Our ref: PL00490033

22nd March 2021

**PLANNING ACT 2008 : THURROCK POWER, PROPOSED THURROCK FLEXIBLE
GENERATION PLANT**

Historic England Deadline 2 Response

Figure 2.2 ZTV and designated heritage assets within a 5km buffer of Zone A

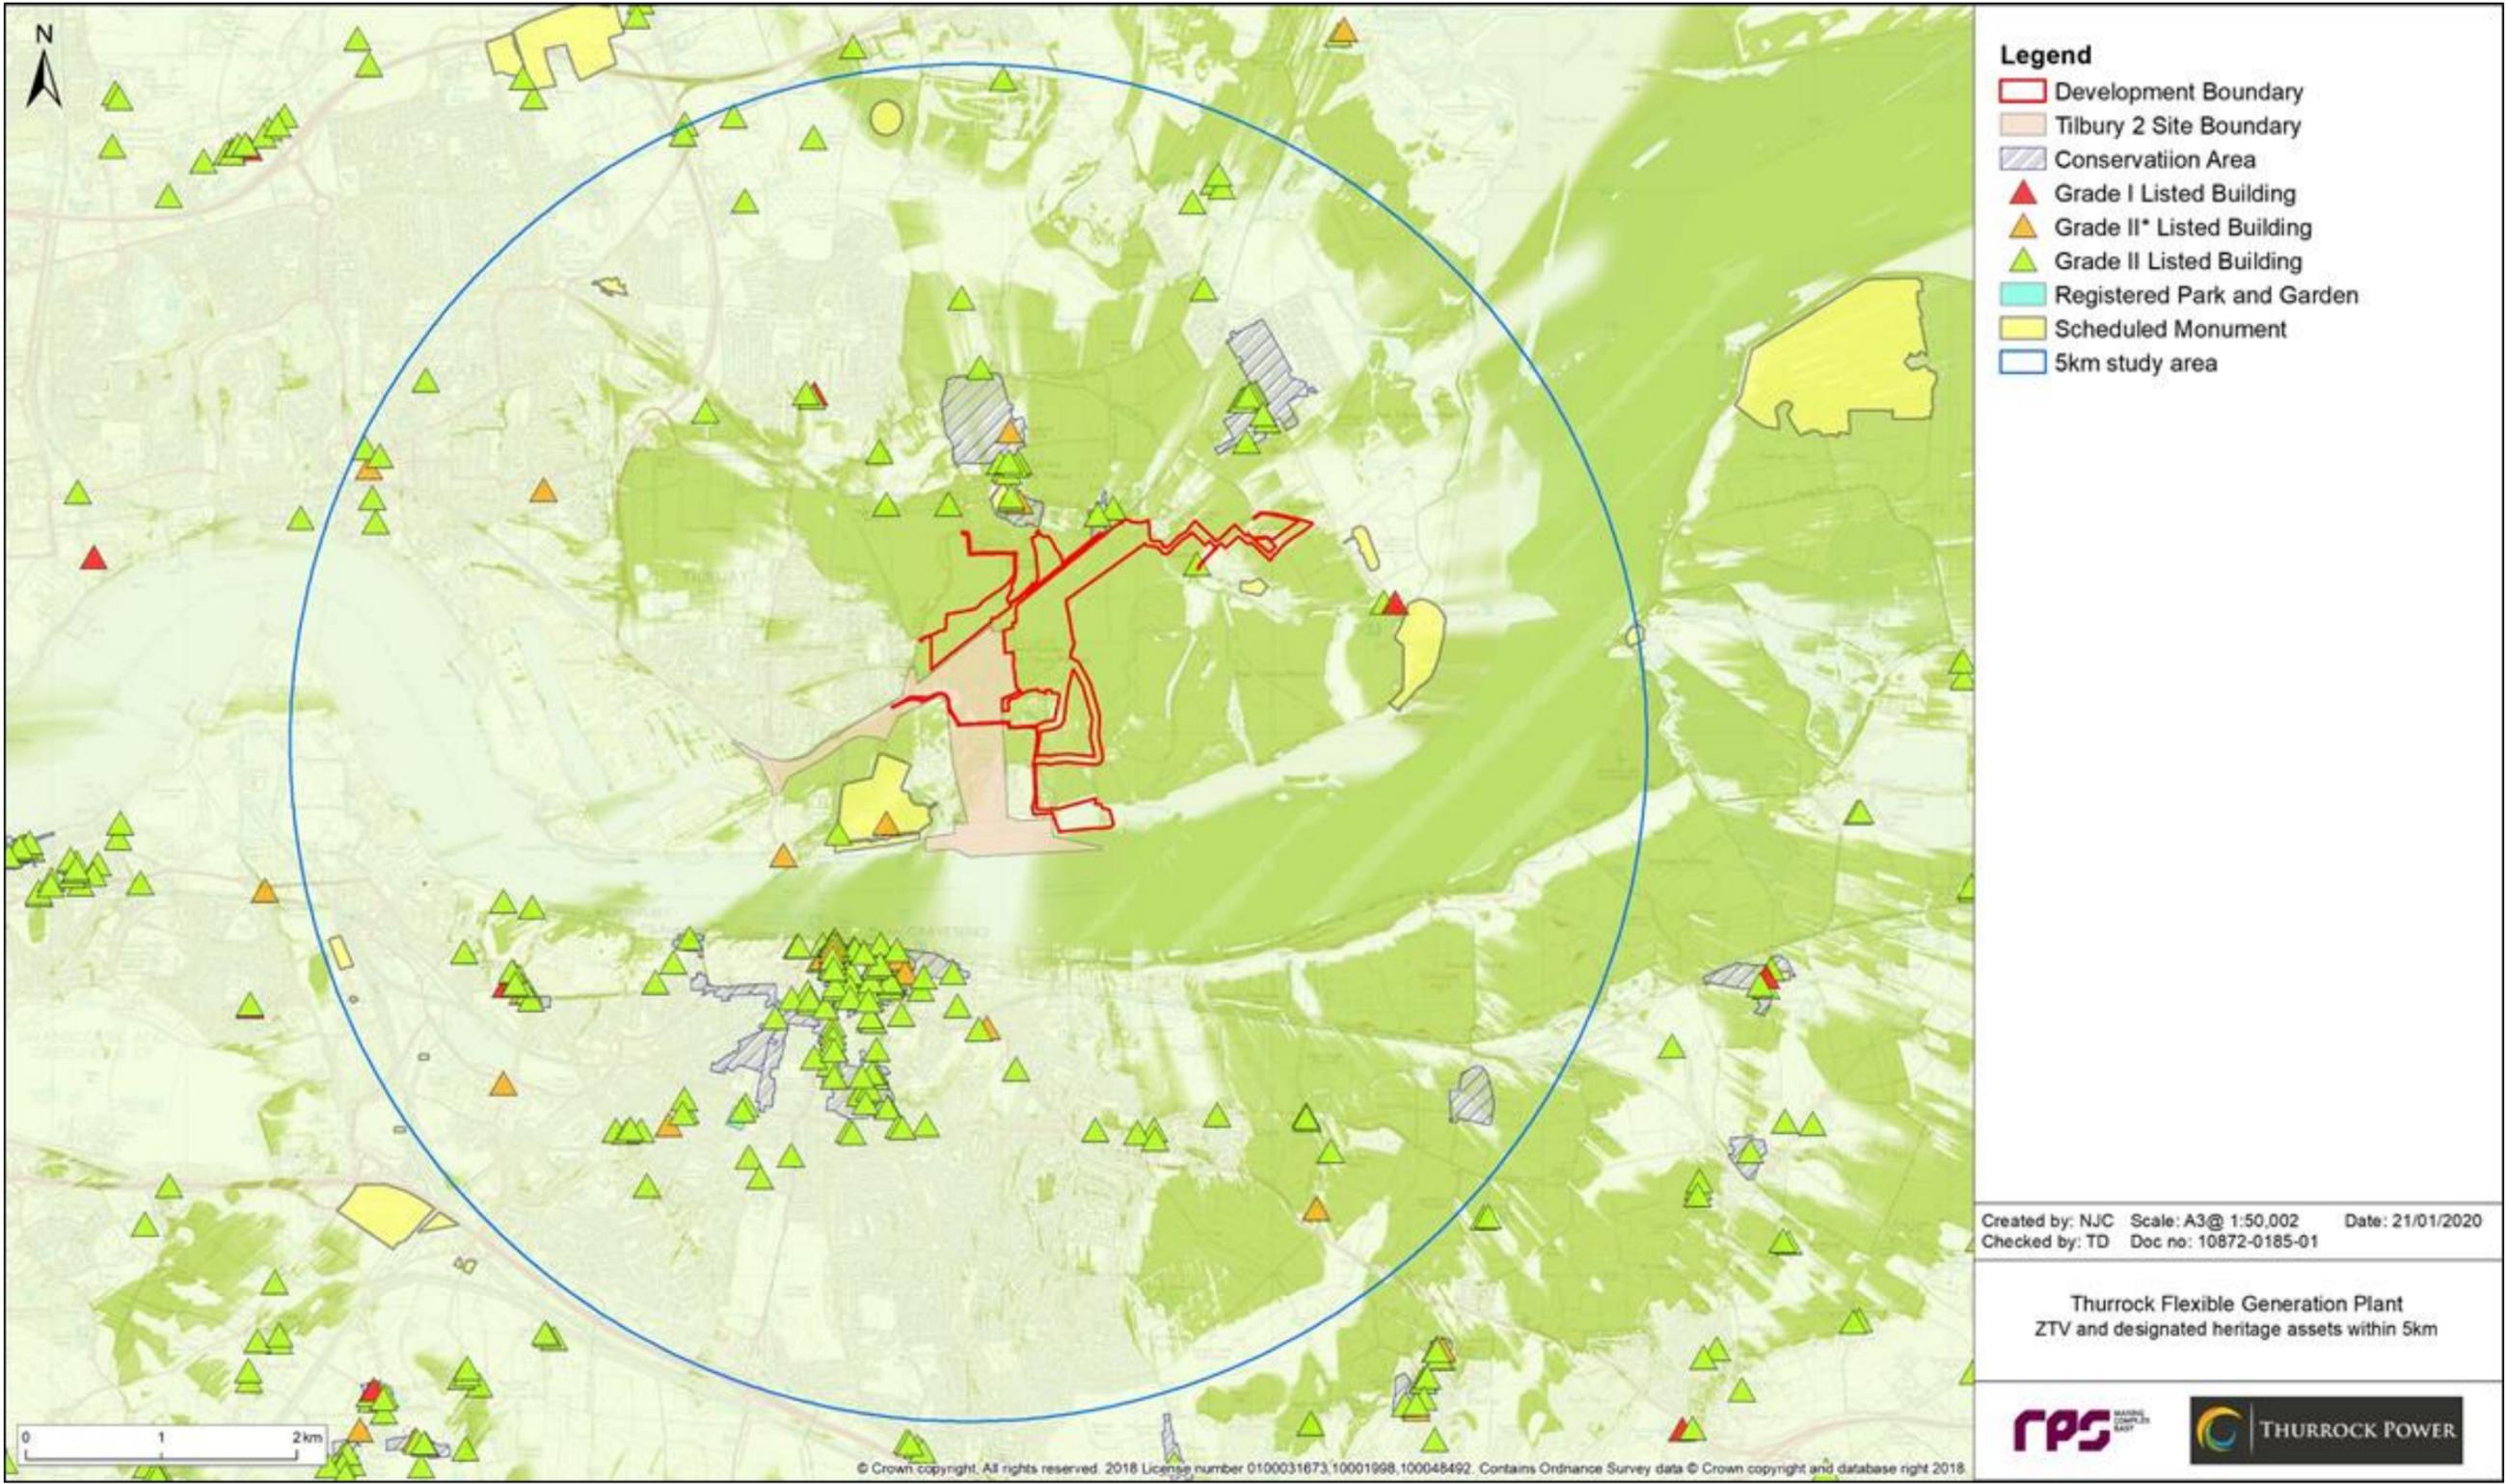
The Grade I Listed Church of St Katherine is located in a prominent topographic location. Figure 2.6: Landscape and Visual Impact Assessment ZTV and 10 km Study Area (Chapter 6: Landscape and Visual Resources Environmental Statement May 2020) indicates that the church lies within the zone of theoretical visibility. Consequently, we have recommended that this designated heritage asset is also included in the assessment. We do not agree that it was right to scope out these designated heritage assets out and consider the applicant should have included these in the initial assessment.
